DOC15/444781-09

STANDARD POST AND EMAIL
22 December 2015

**SITA Australia Pty Ltd - State Significant Development Application - SSD 14_6835
Lucas Heights Landfill and Resource Recovery Expansion
New Illawarra Road, Lucas Heights**

<i>Attachment 1</i>	<i>EPA request for additional information on the Noise Assessment</i>
<i>Attachment 2</i>	<i>EPA request for additional information on the Air Assessment</i>
<i>Attachment 3</i>	<i>EPA request for additional information on the Surface Water Assessment</i>
<i>Attachment 4</i>	<i>EPA request for additional information on the Leachate Assessment</i>

Figure 2.3 ARRT Facility Layout

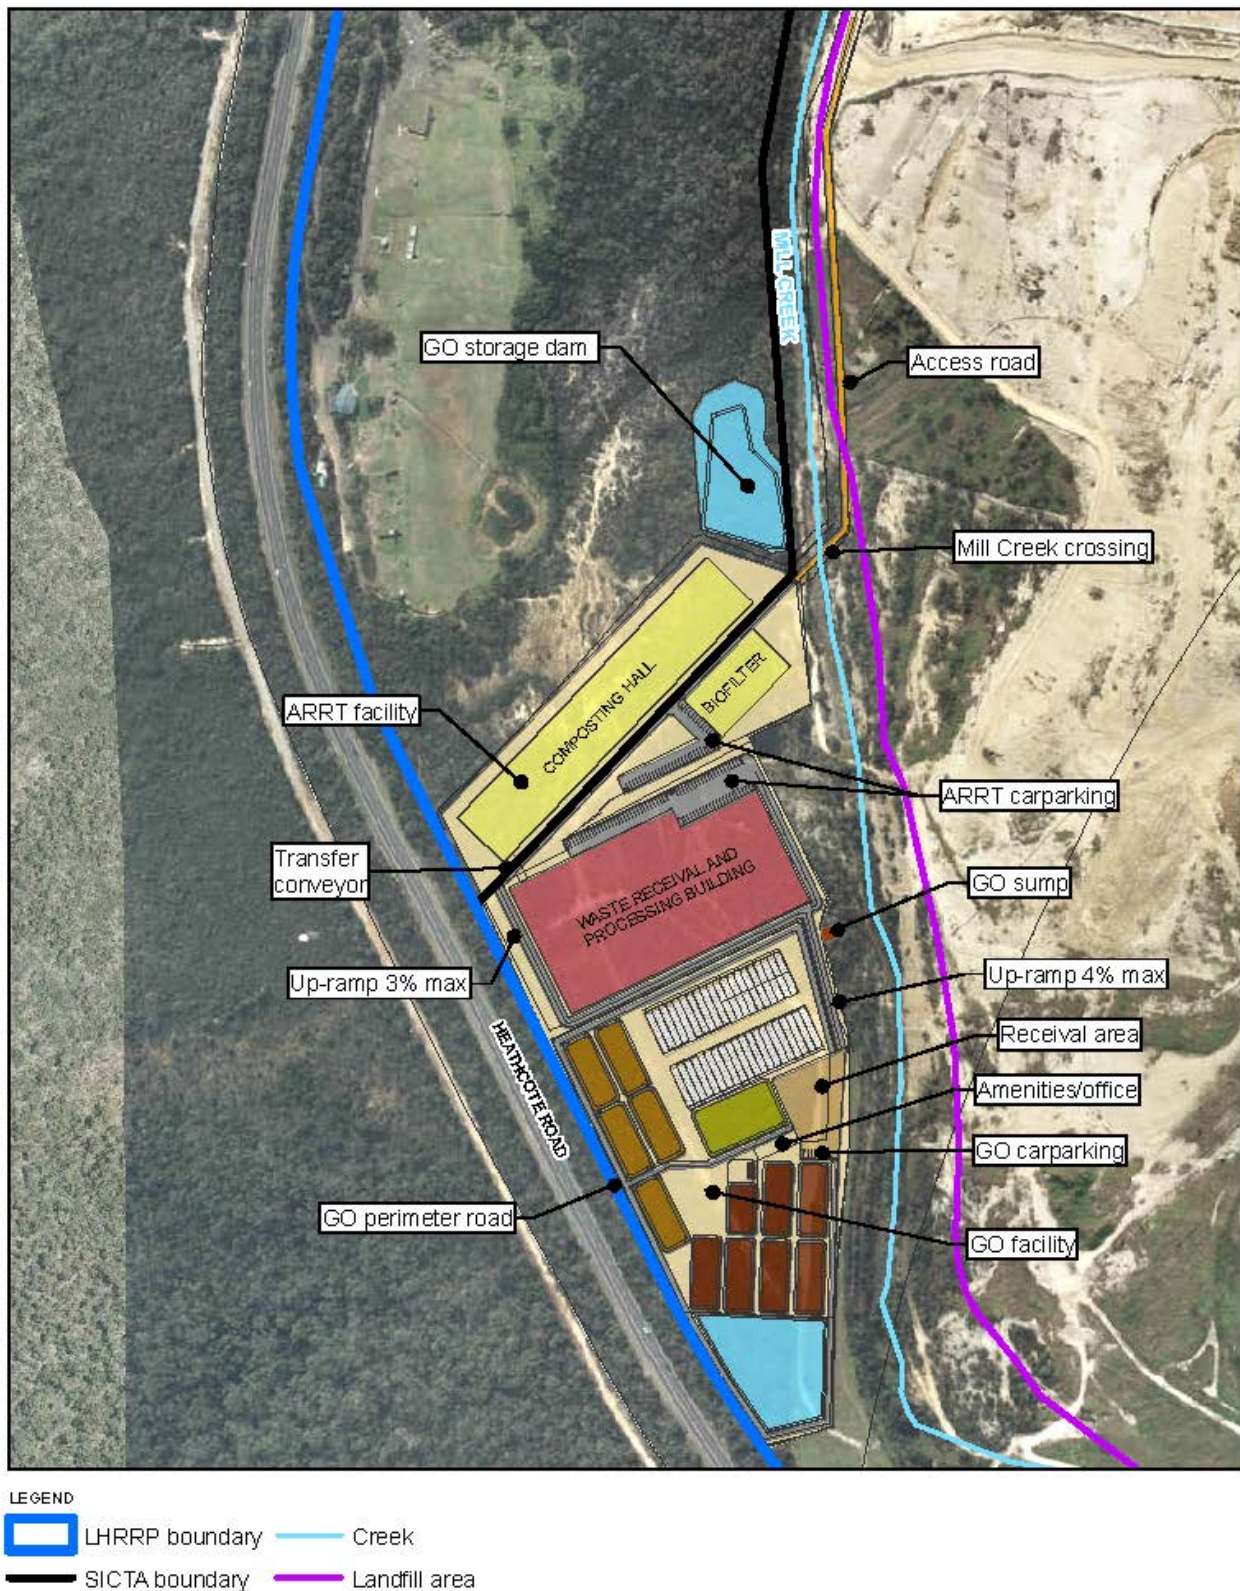
The EPA notes that there is a conveyor belt that travels between the ARRT Waste Reveal and Processing Building to the ARRT Composting Hall.

- a) The EPA requests clarification on whether the will be enclosed?
